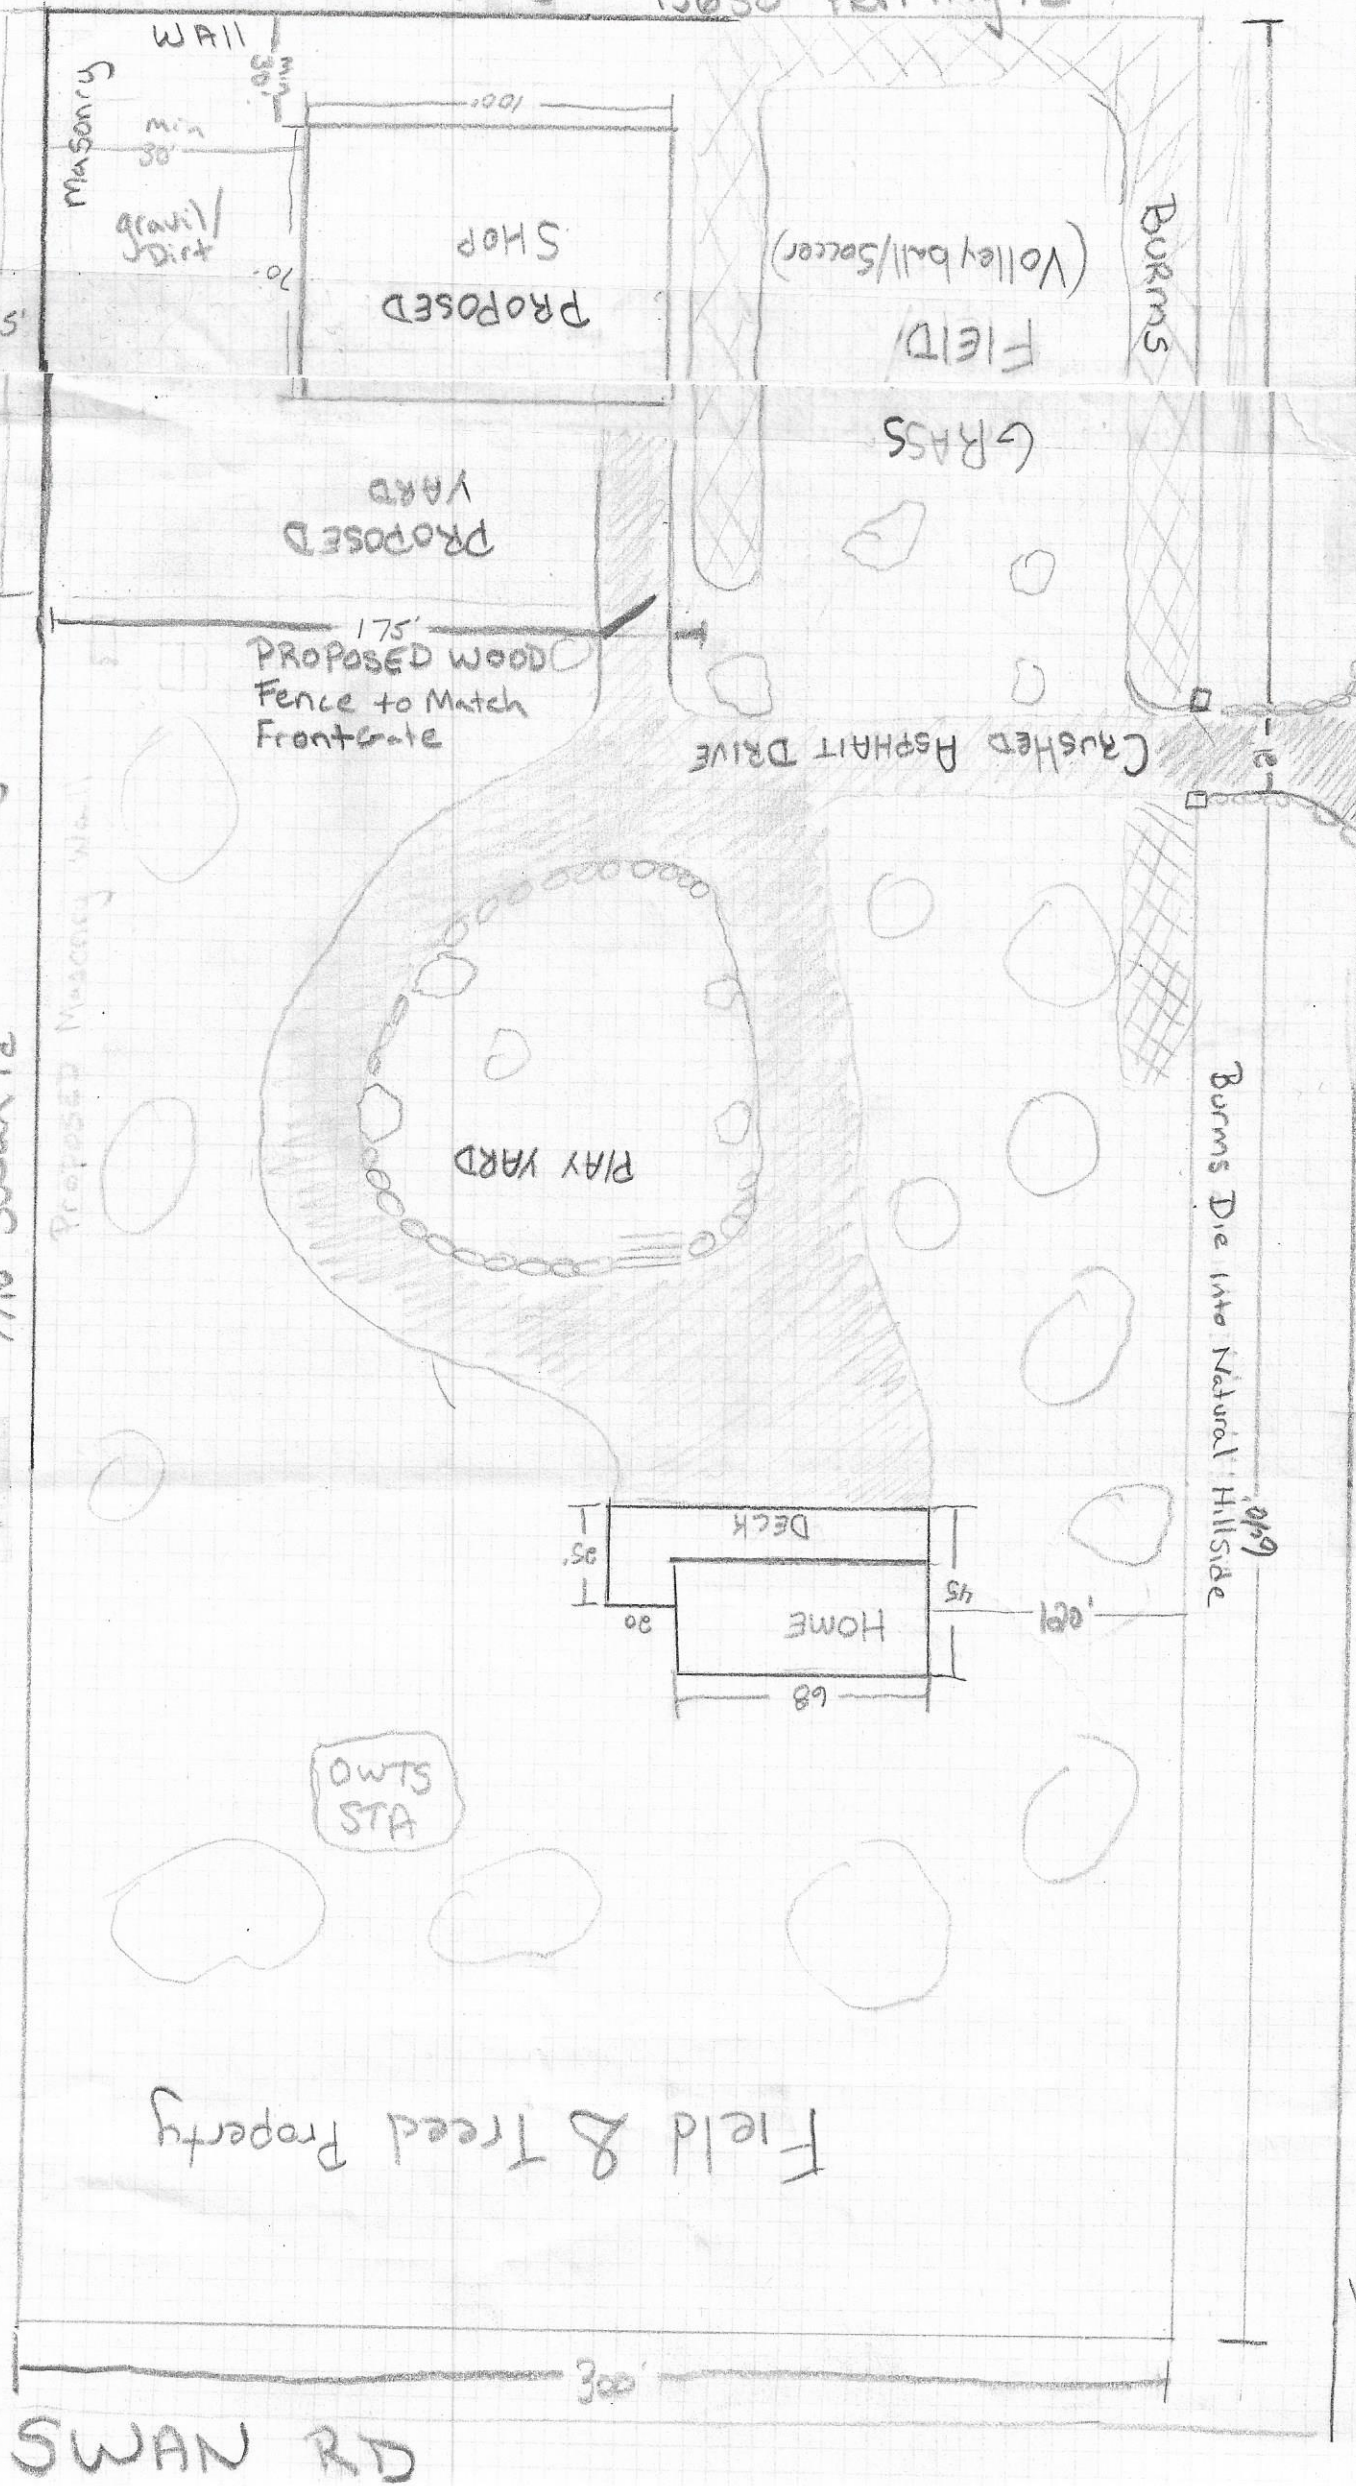
As discussed during the EA, the vicinity map need to be pulled from the Assessors' website. However, these owners and addresses need to be depicted on site plan as well.
